Application no: 21/02496/DISC

Location: Land to The South and adj to, South Side, Steeple Aston.

Transport Development Control

Recommendation

HIGHWAY CROSSOVER FROM SOUTH SIDE  
Scale 1:20

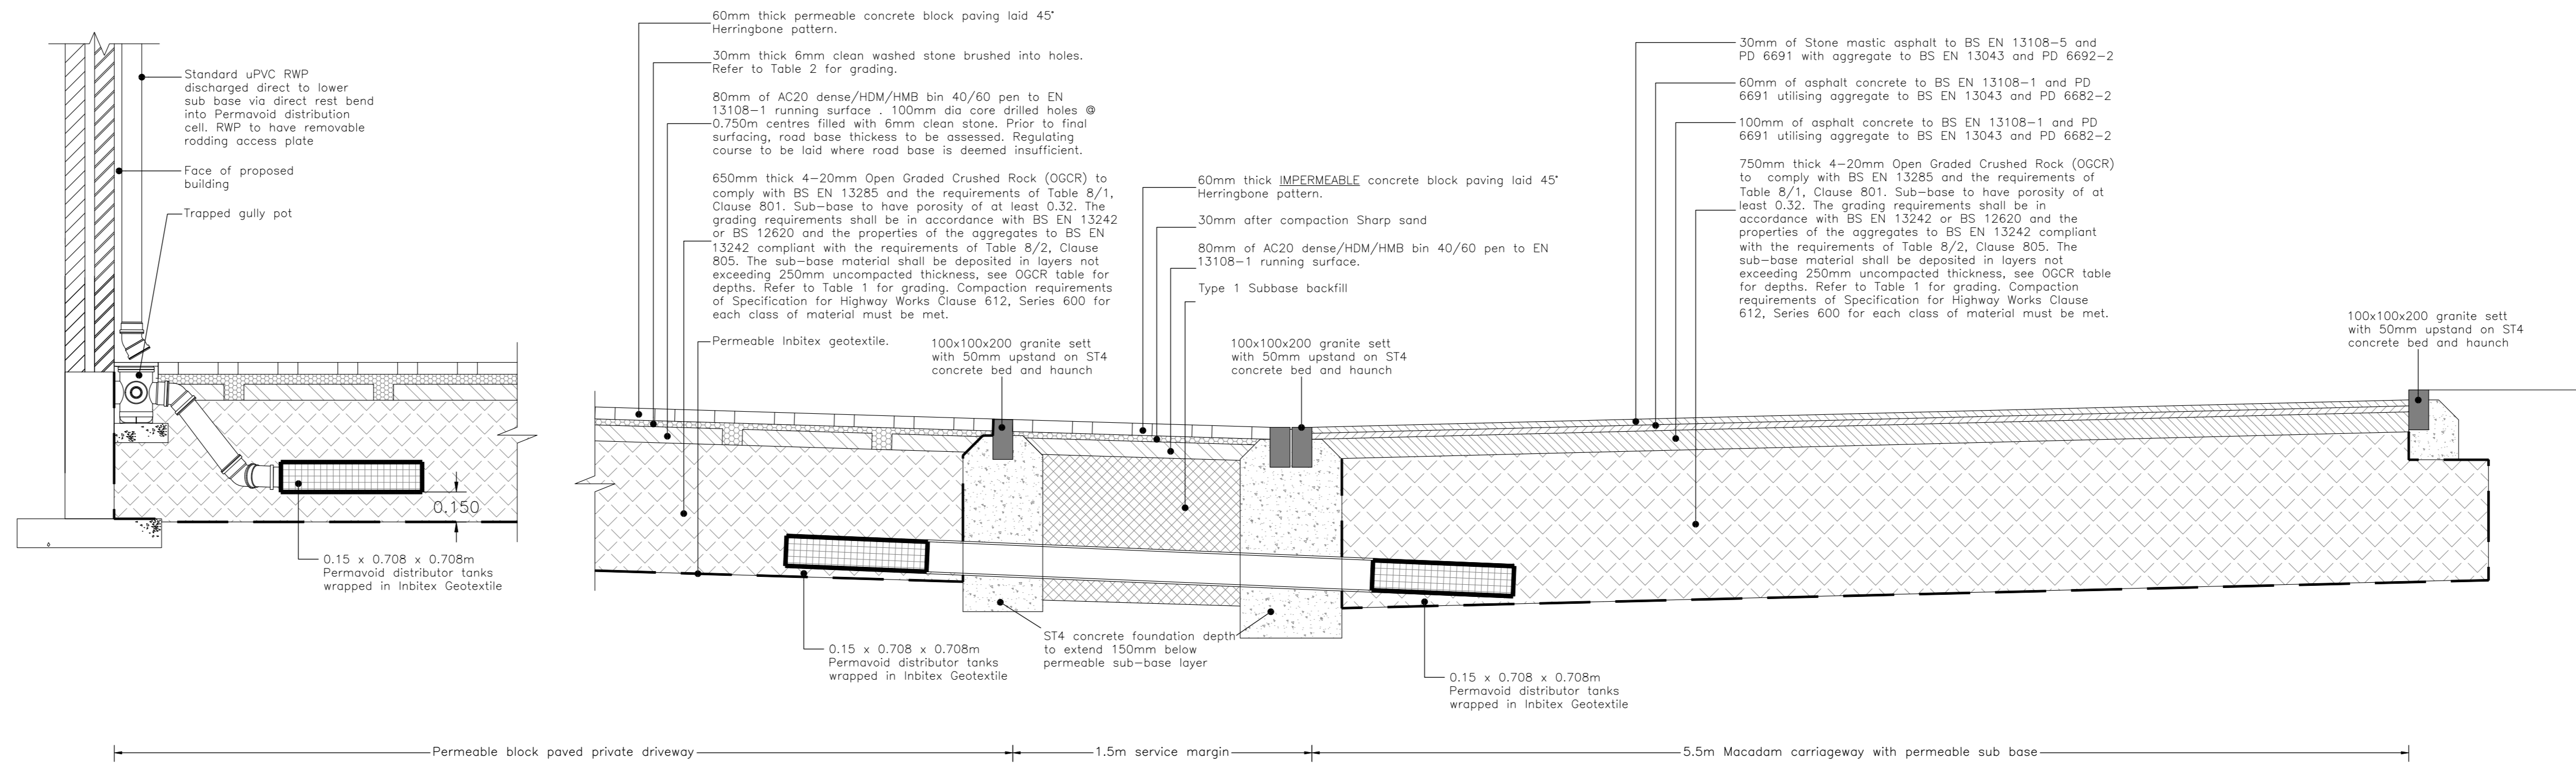
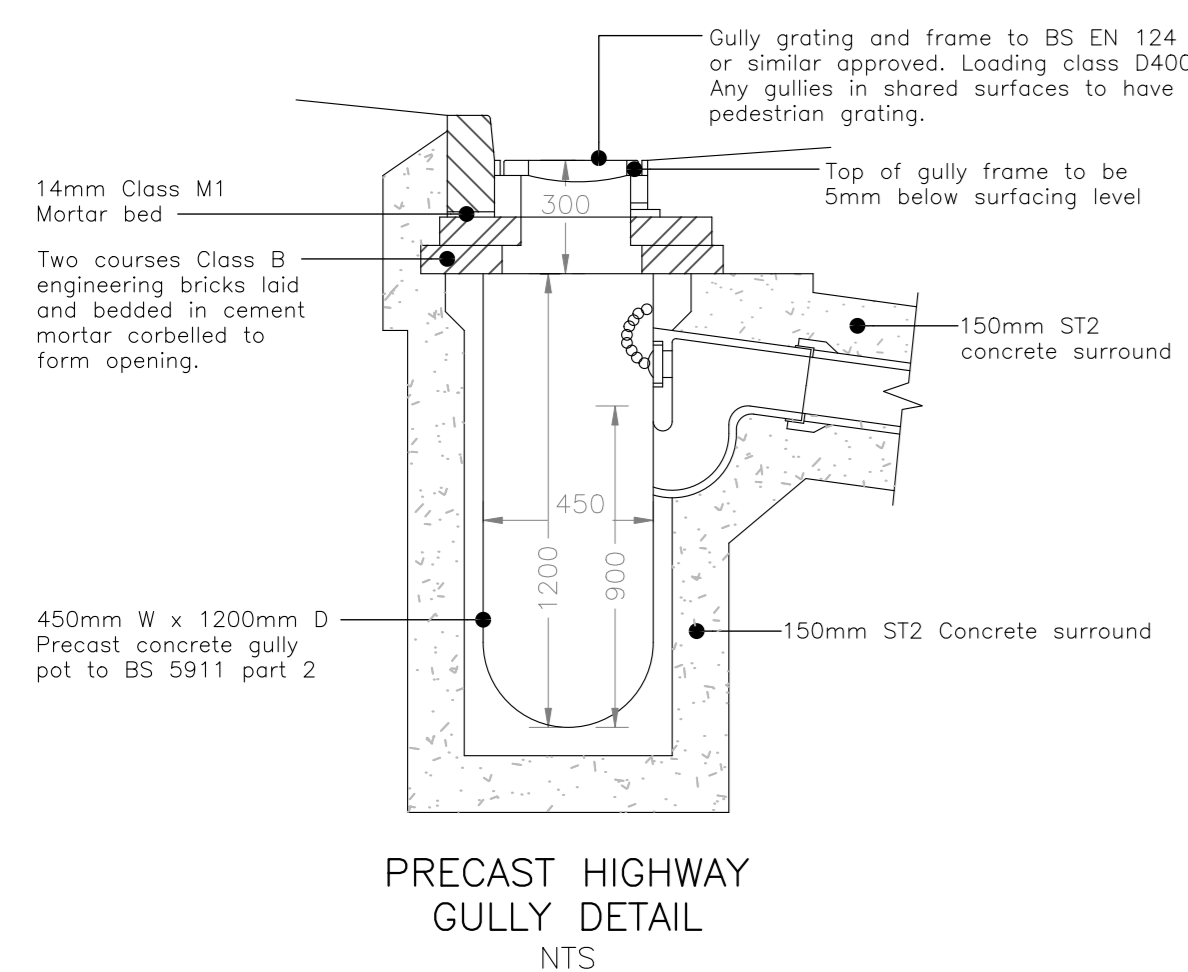
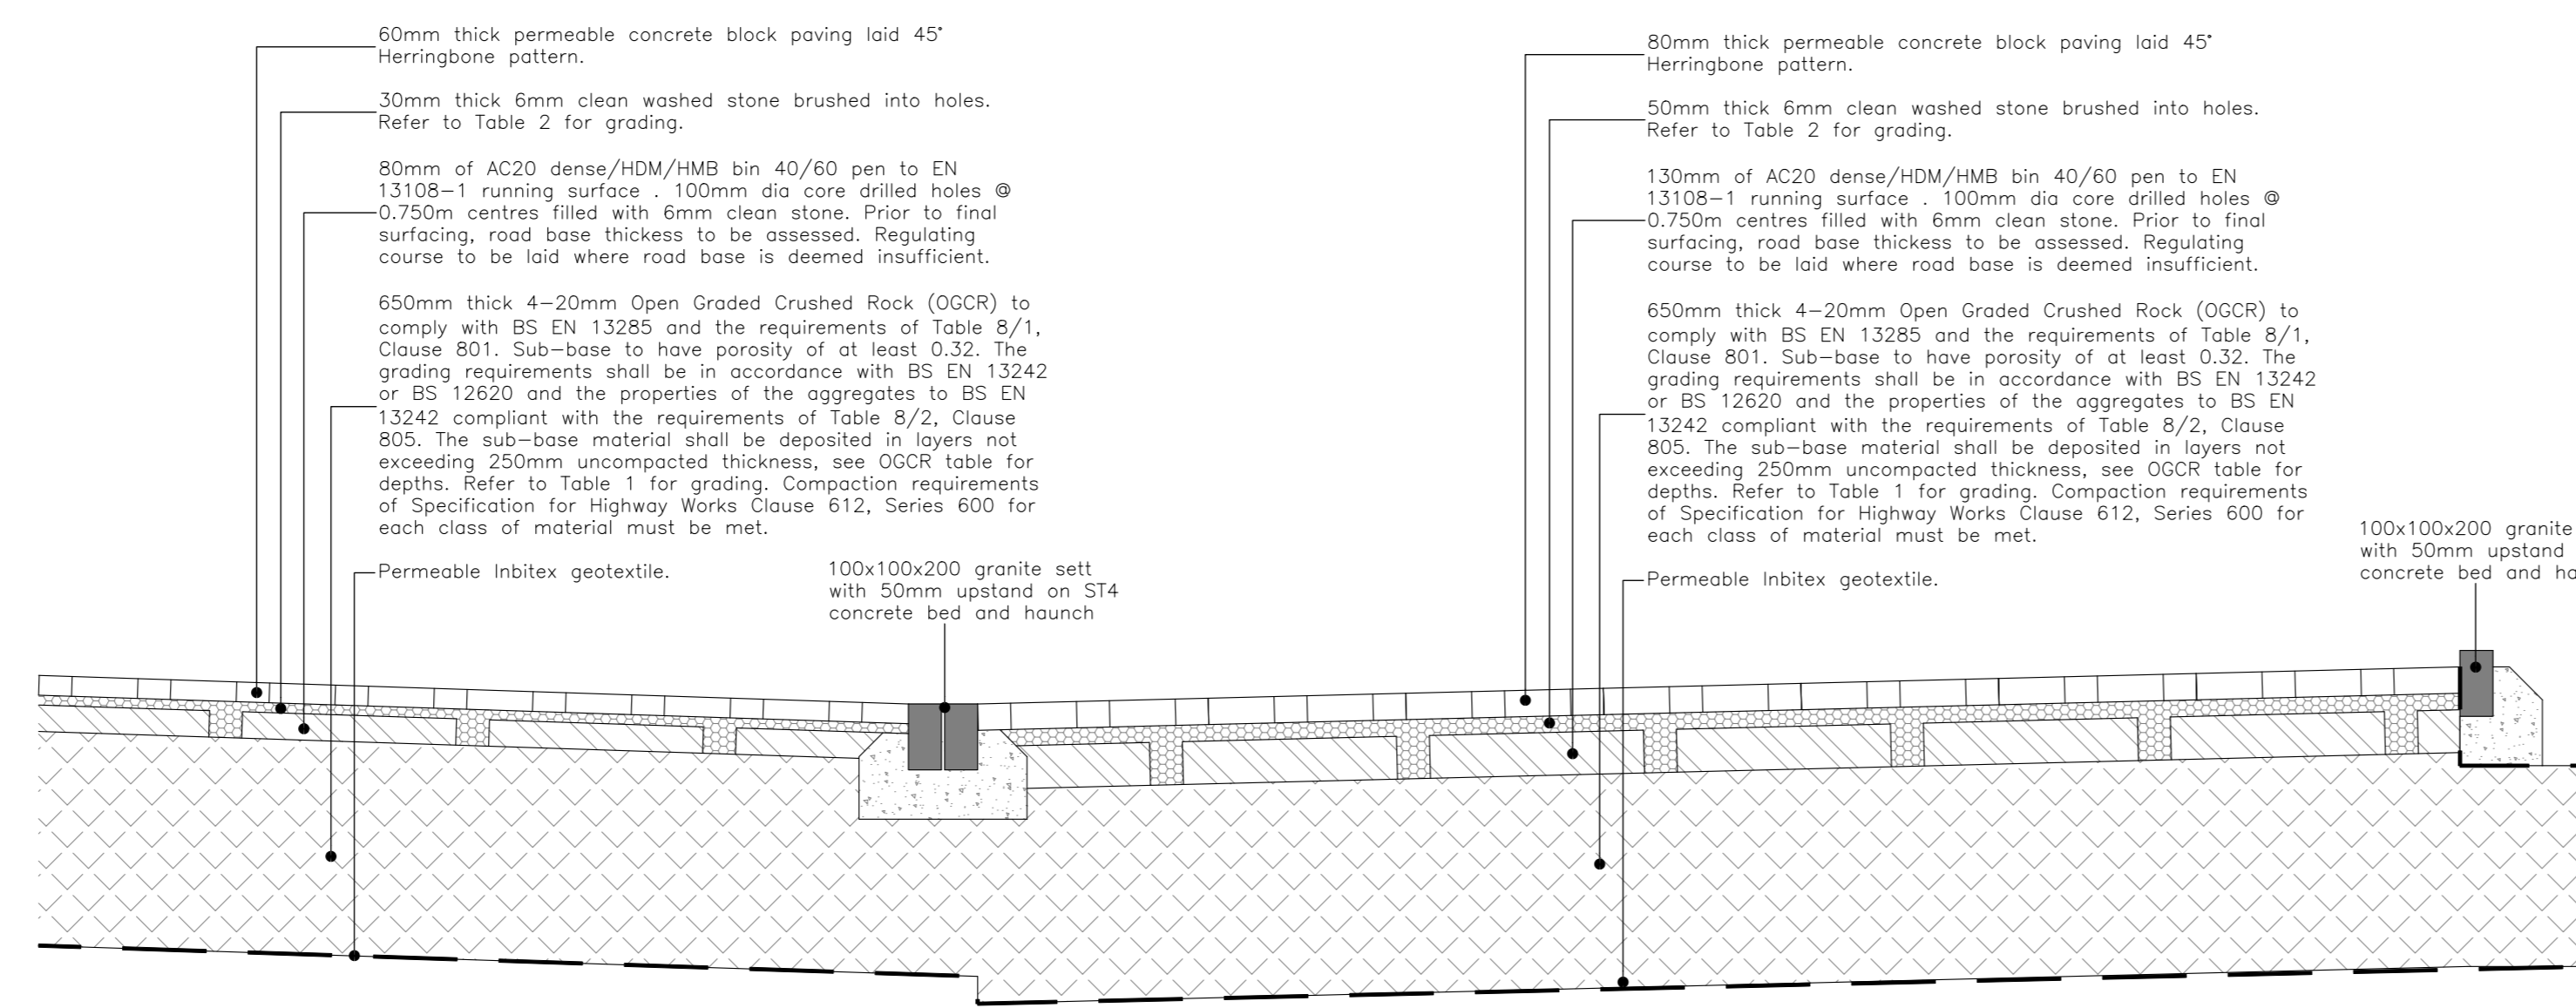
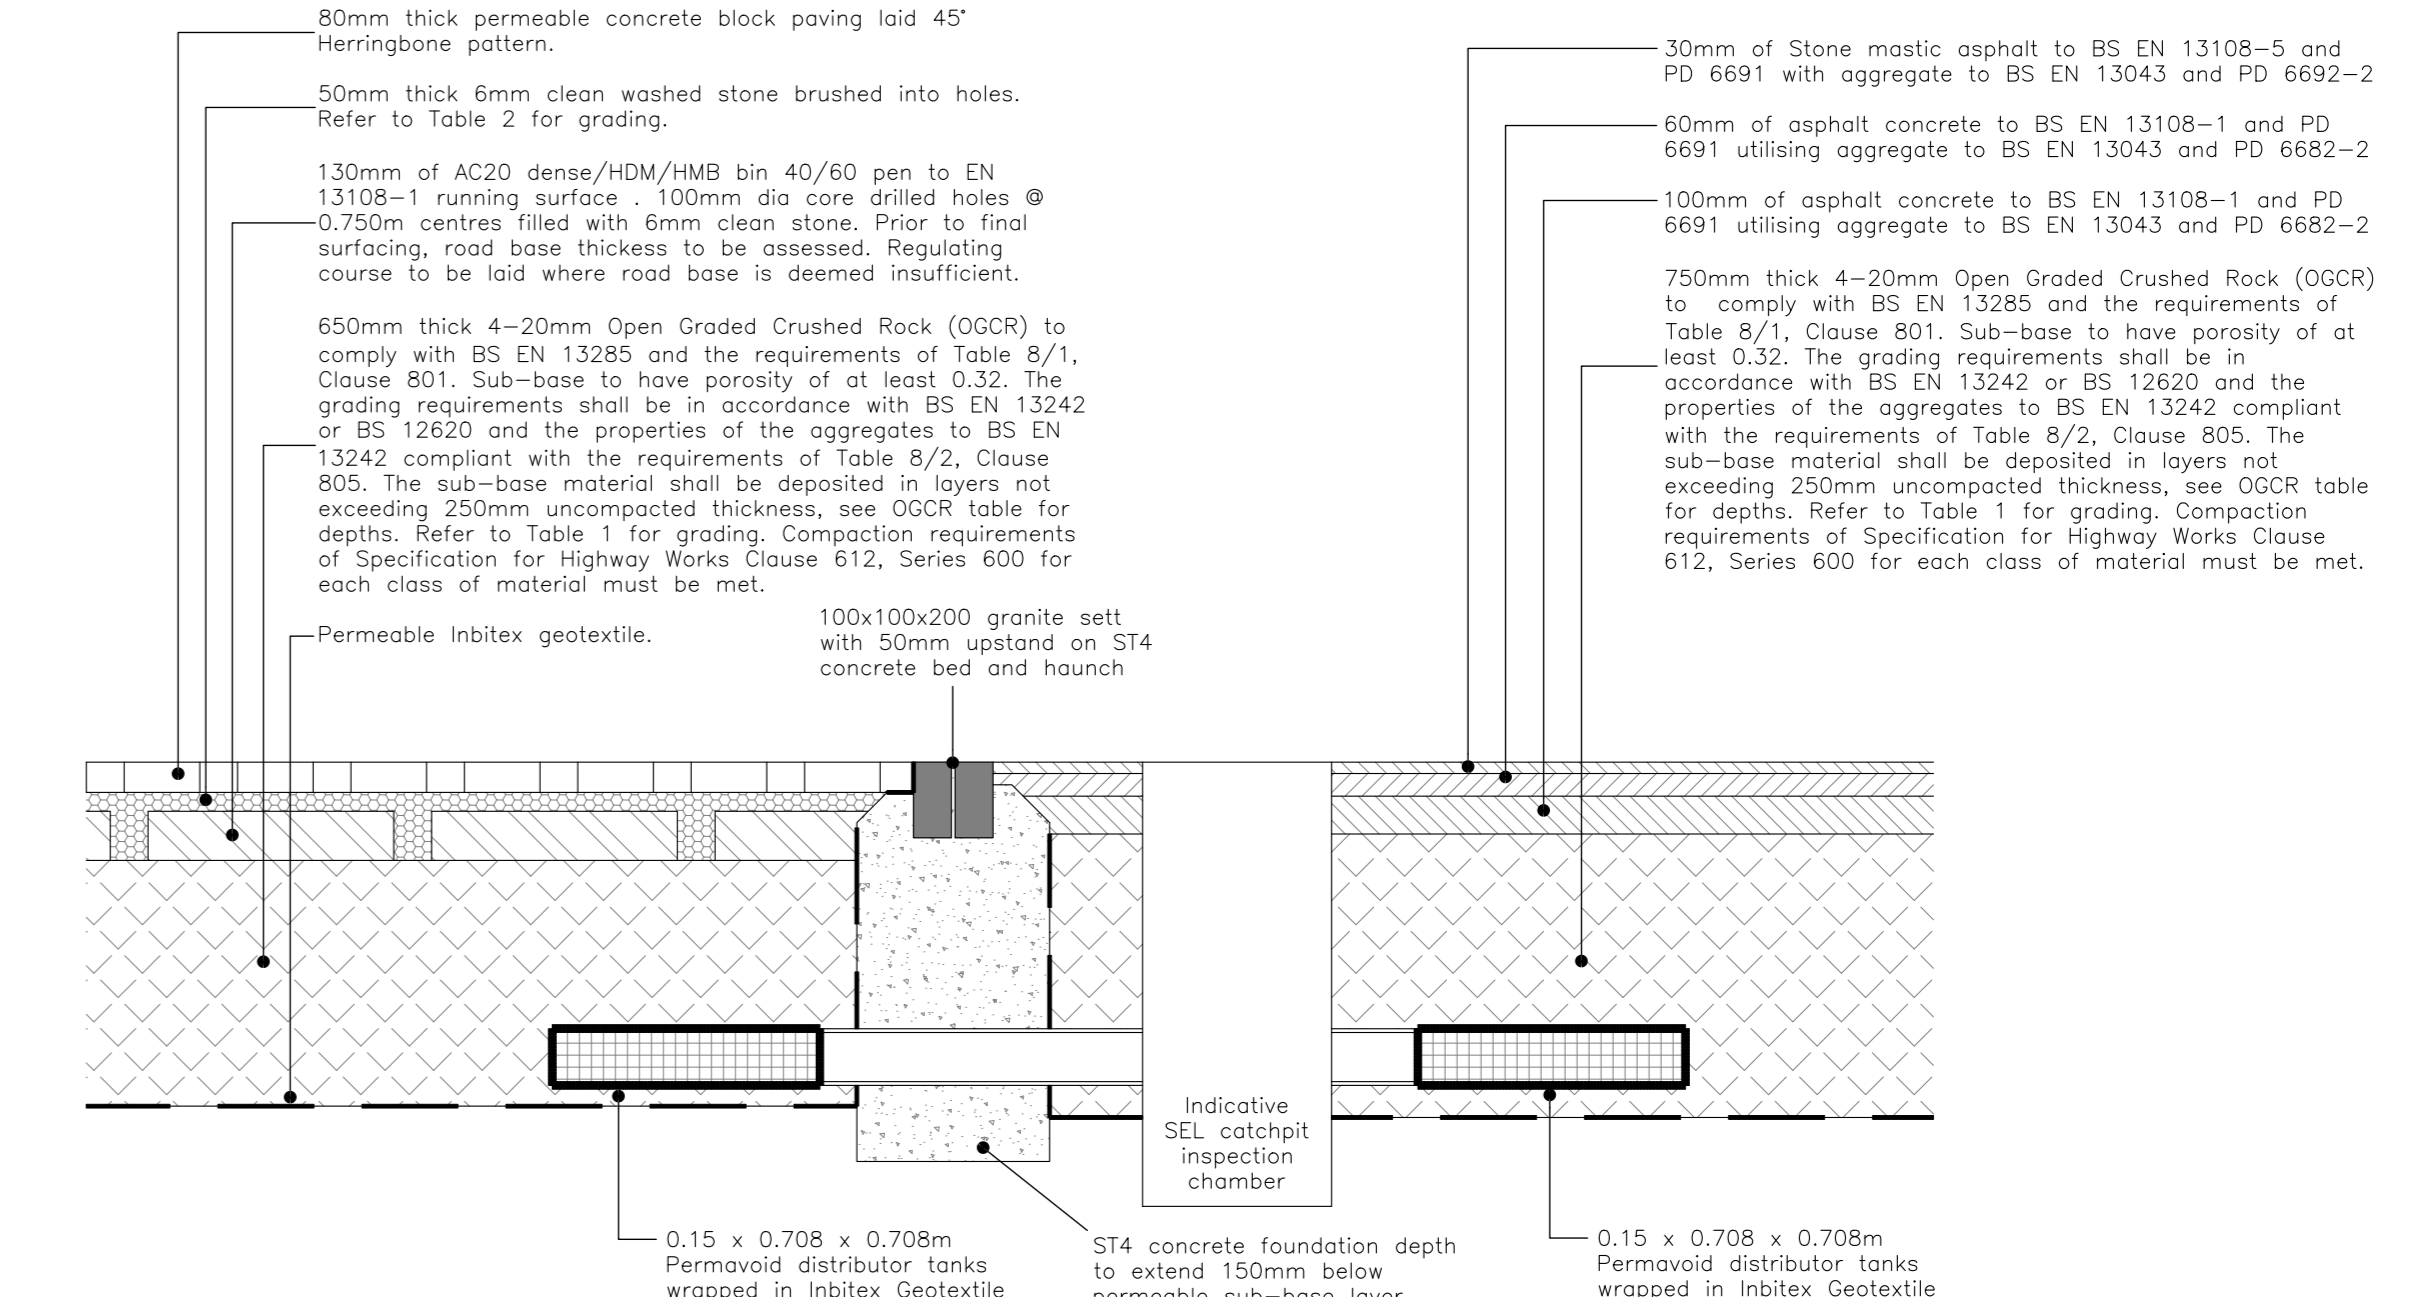
The County's Road Agreements team has not received any form of Section 278 application for this development and therefore no plans or details have been reviewed under its technical audit process. As such, the County's Road Agreements team is unable to recommend discharge of this condition at this stage as it is not in a position to confirm whether the details submitted are suitable to satisfy the condition. **Reason for objection.**
